Subject: FW: Response To Application Number Y/131/20/DOC at Land south of Ford Lane and East of North End Road, Yapton

Please upload onto Ocella the email below which is a further consultation response from the Local Highway Authority to discharge of condition application **Y/131/20/DOC**.

The consultation requiring comments in response to the PRoW and the cycleway across the site and the connections to Ford Lane should be under **Condition 8** of discharge of condition application **Y/131/20/DOC**.

Drawing Title
Sections through public right of way footpath 357

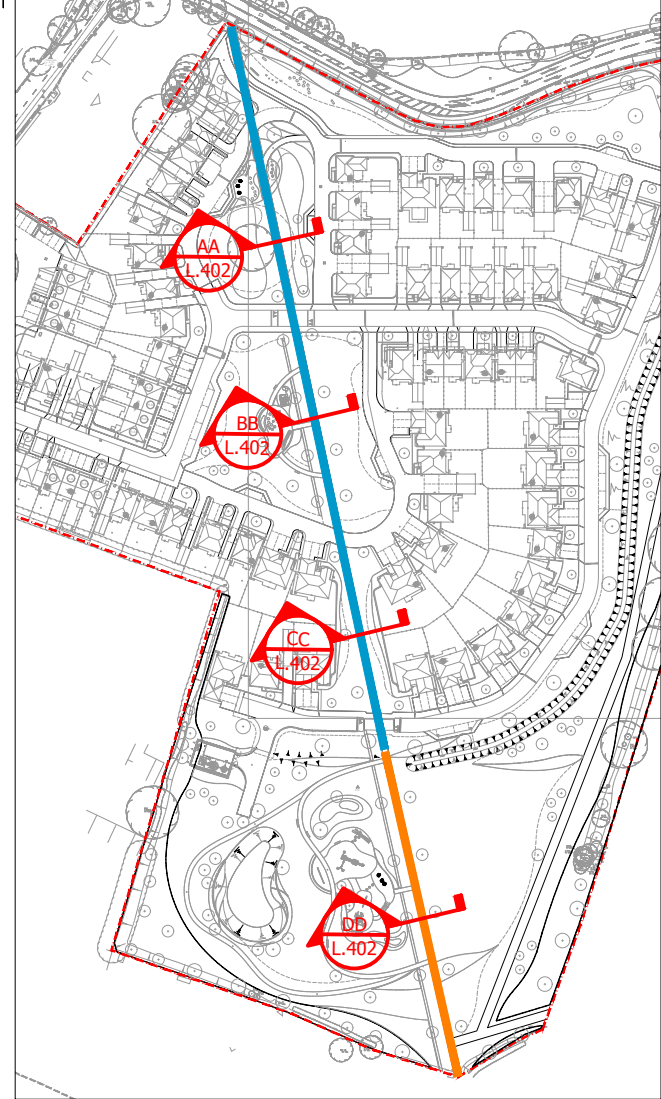
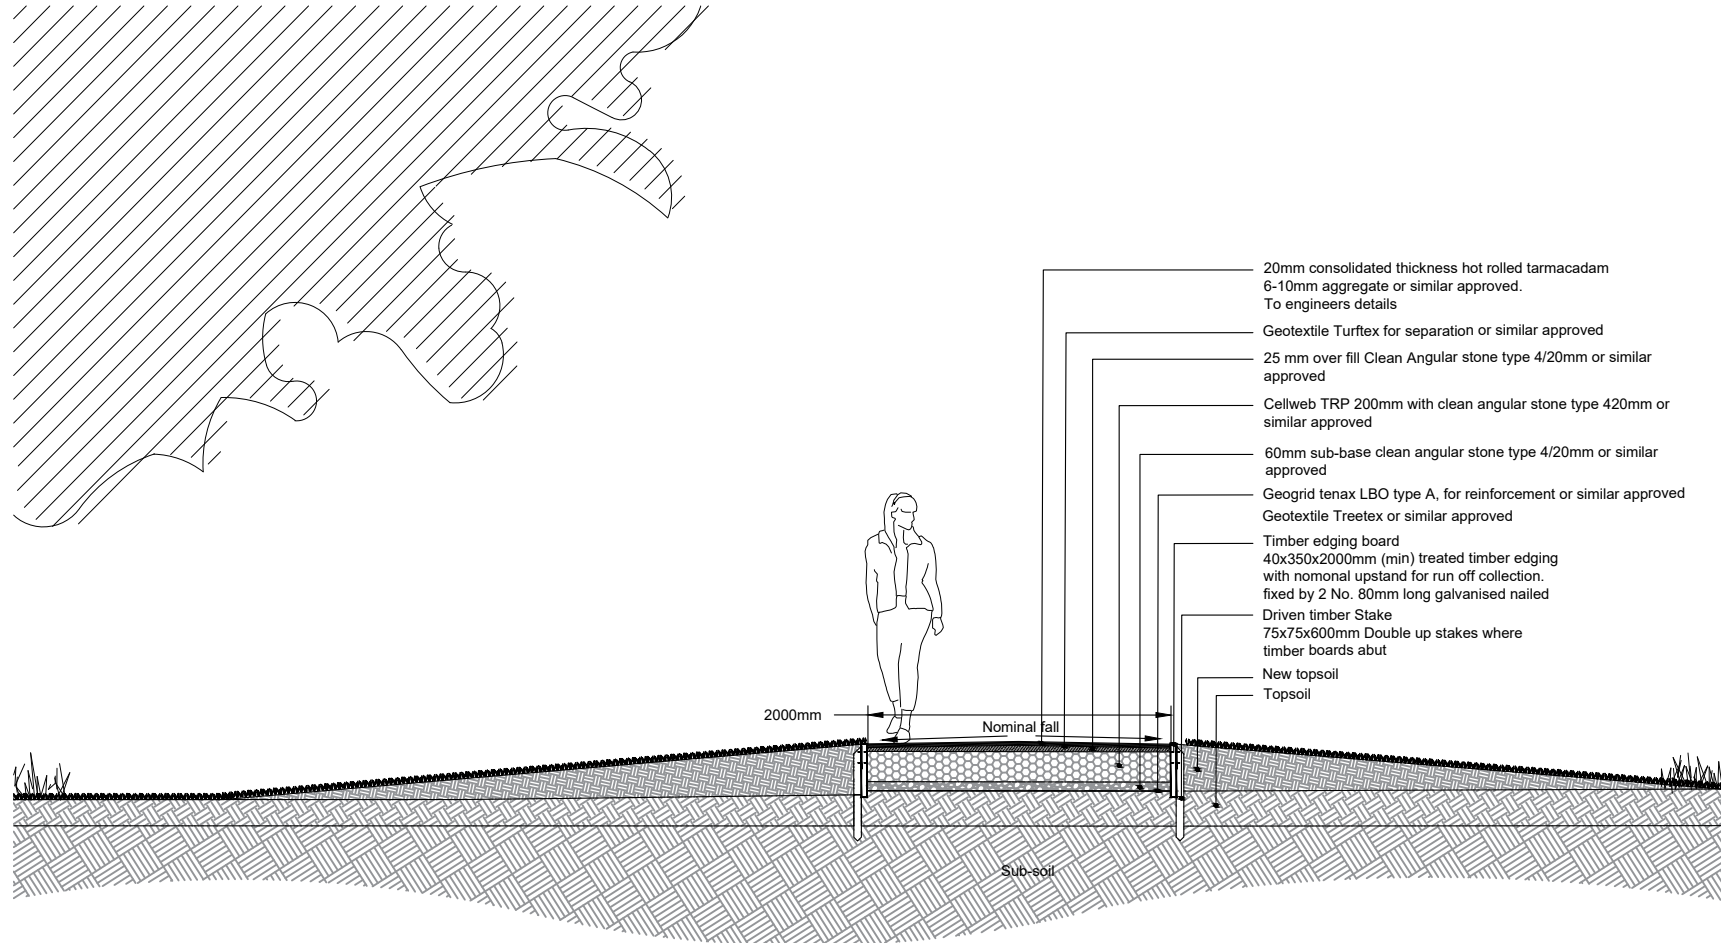
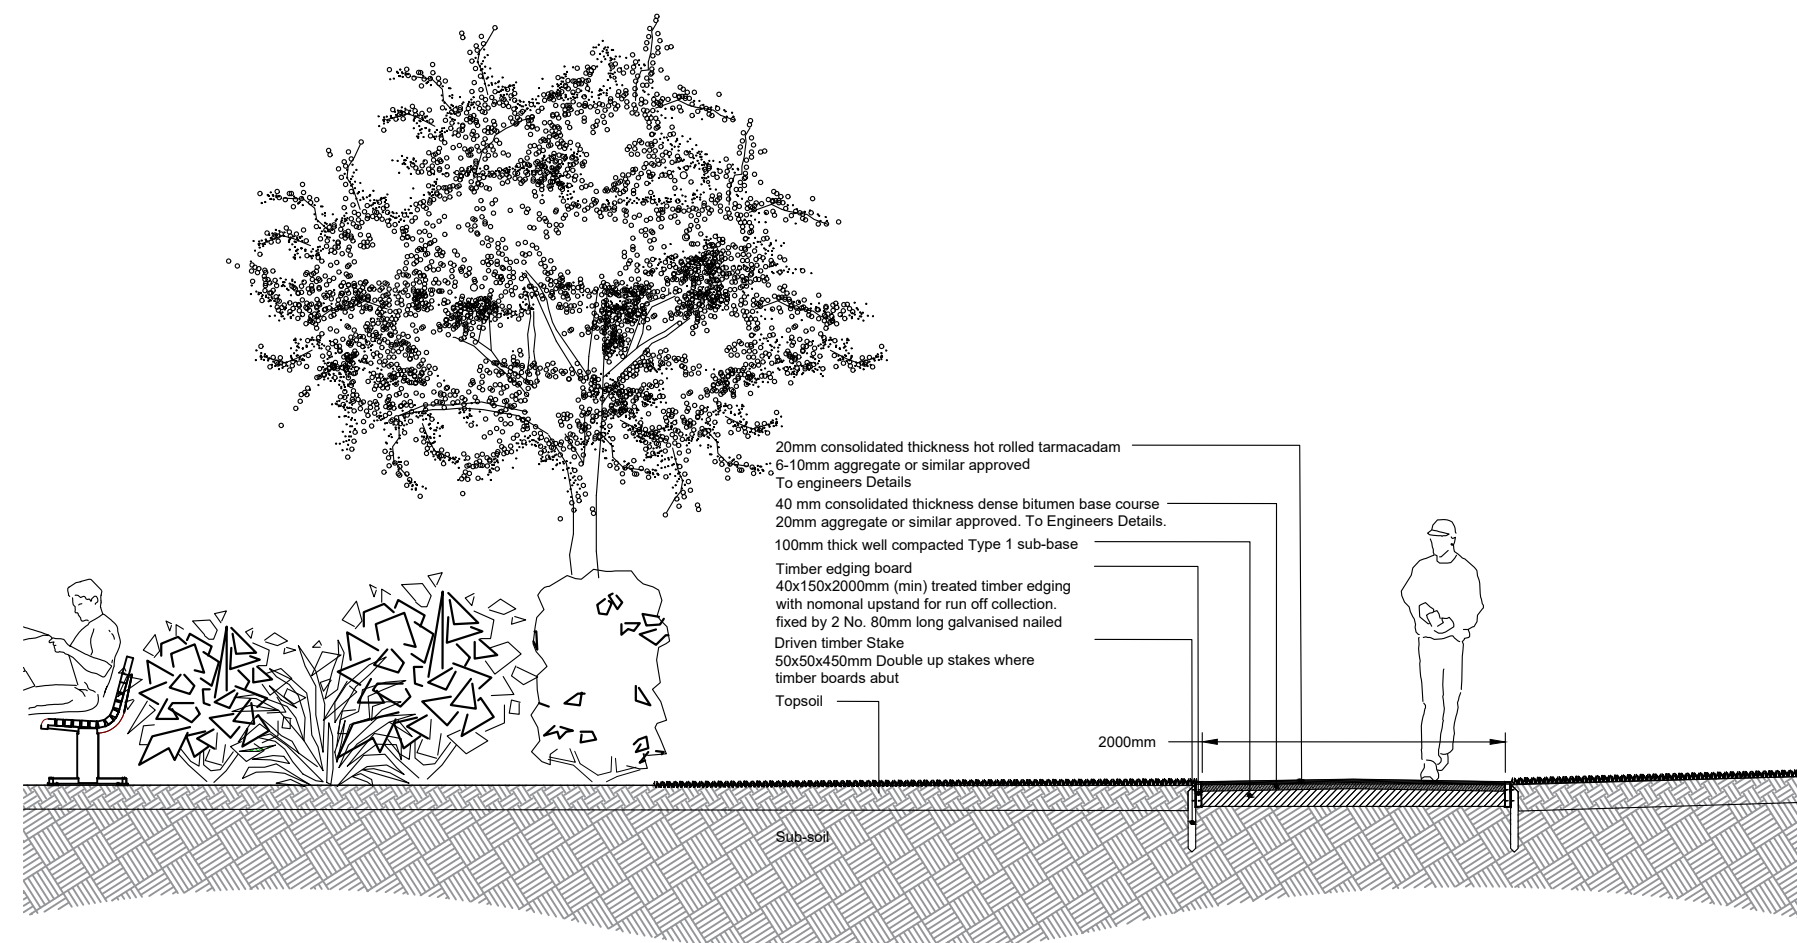
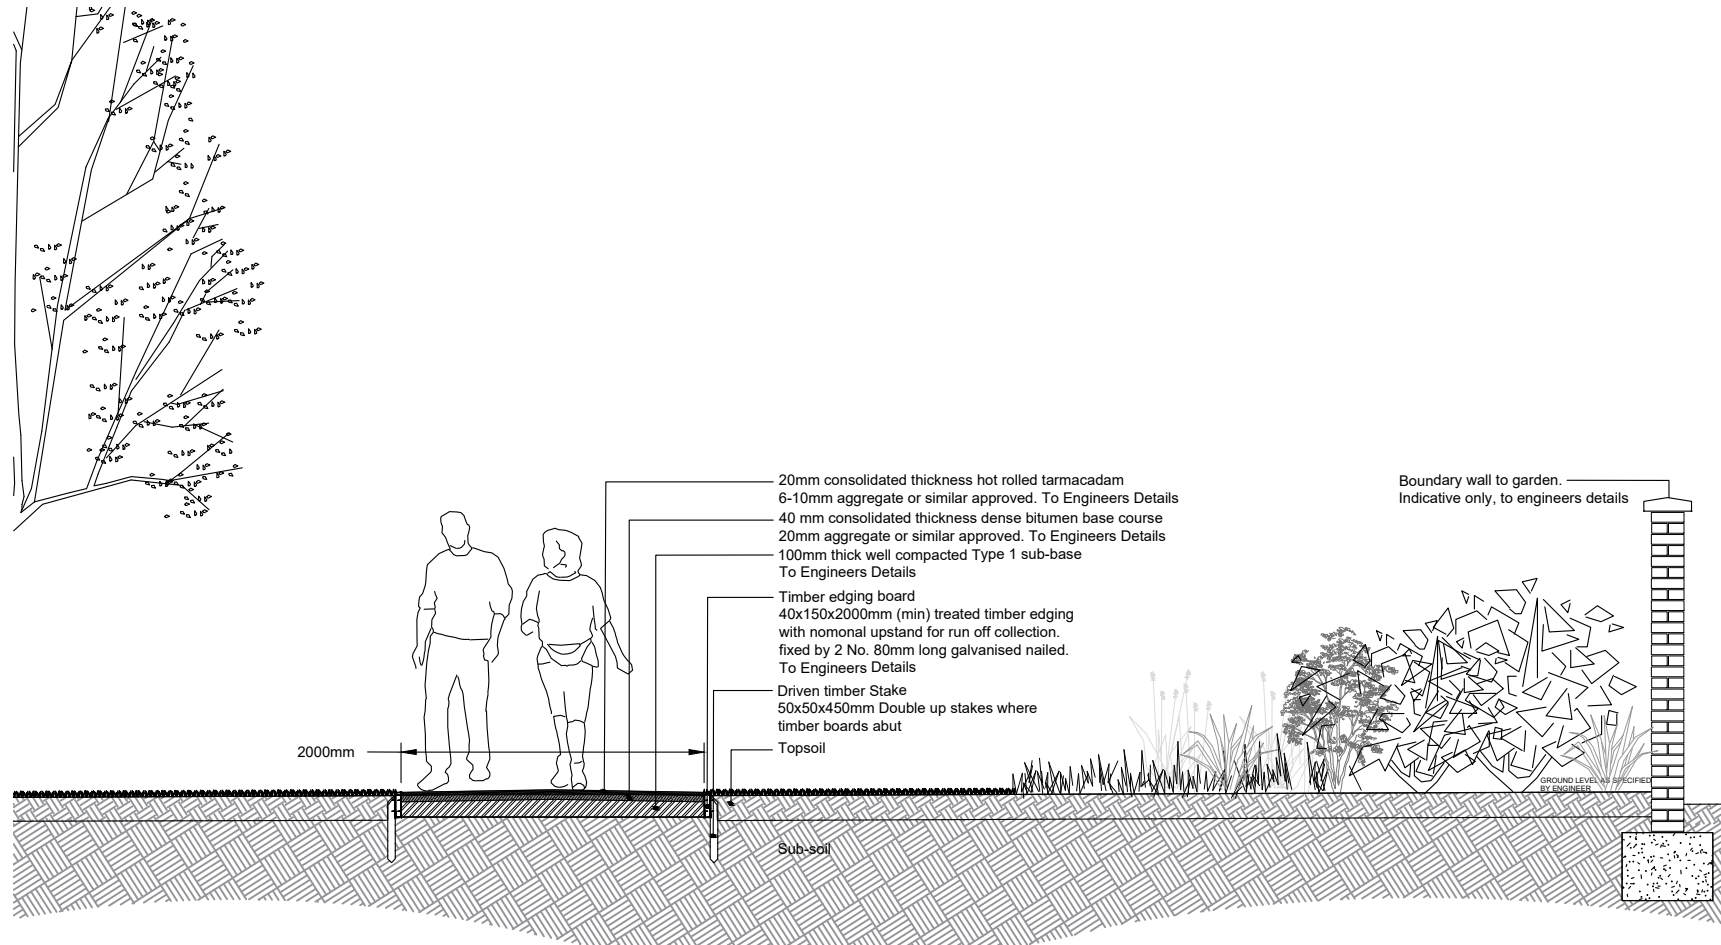
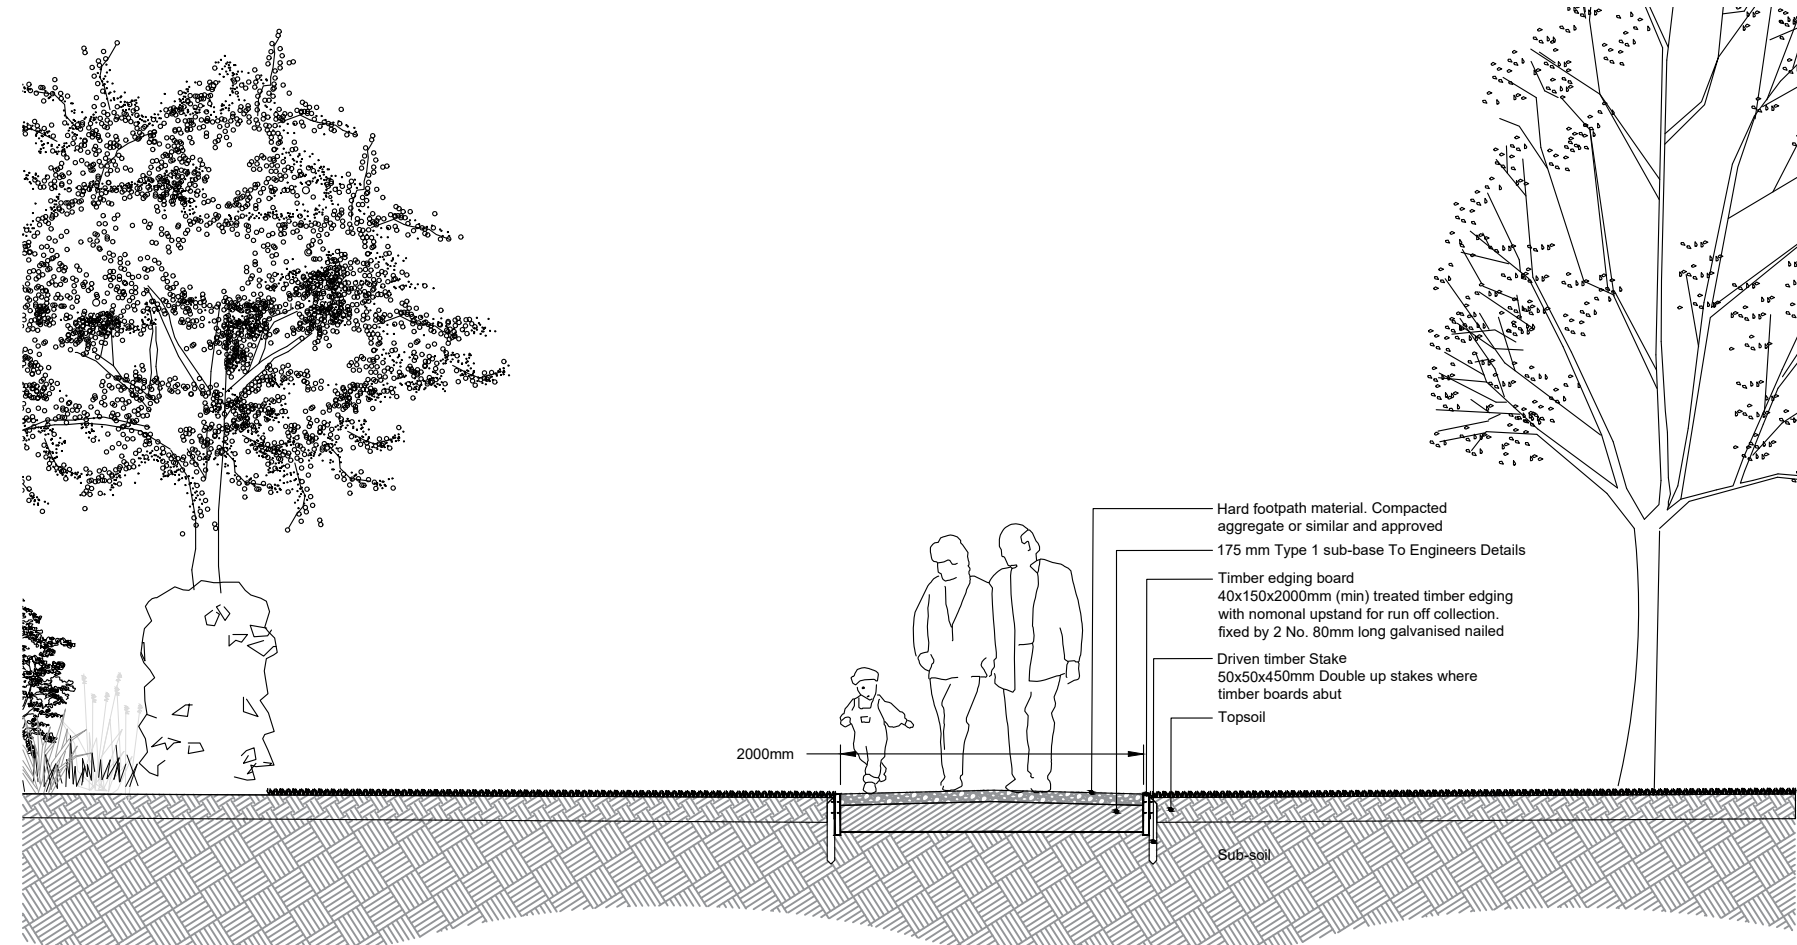
It would be advisable if the existing Footpath 358, which runs along the Eastern side of the site be referred to as 'Proposed Bridleway' as this is our eventual aim and this will avoid confusion as we proceed. Likewise existing Footpath 357 across the site should be denoted as 'Proposed Cycleway' for the same reason.

My understanding is that the applicant in their 'movement/accessibility plan' has accepted the principle of Public Footpath 357 becoming a shared foot and cycle way whereas Public Footpath 358 will be upgraded to Bridleway status. As such we would need to see the details of how they join and interact at the points they join Ford Lane and how they terminate south of the site. This will require plans from the applicant and either a further Stage 1 Road Safety Audit or Supplementary Road Safety Audit (if the latter is permitted under GG119) to ensure that any changes required as a consequence of the change of status of the paths has been properly considered. Another PROW - Public Footpath 359 - shouldn't need altering at the present time other than the developer confirming that space either side would not be encroached upon as part of this development. The reason for this is that if development comes forward to the east at some time in the future there would then be scope to upgrade this path too. Including the path, an overall width of 5.0m would be sufficient taking the path as centreline to this.
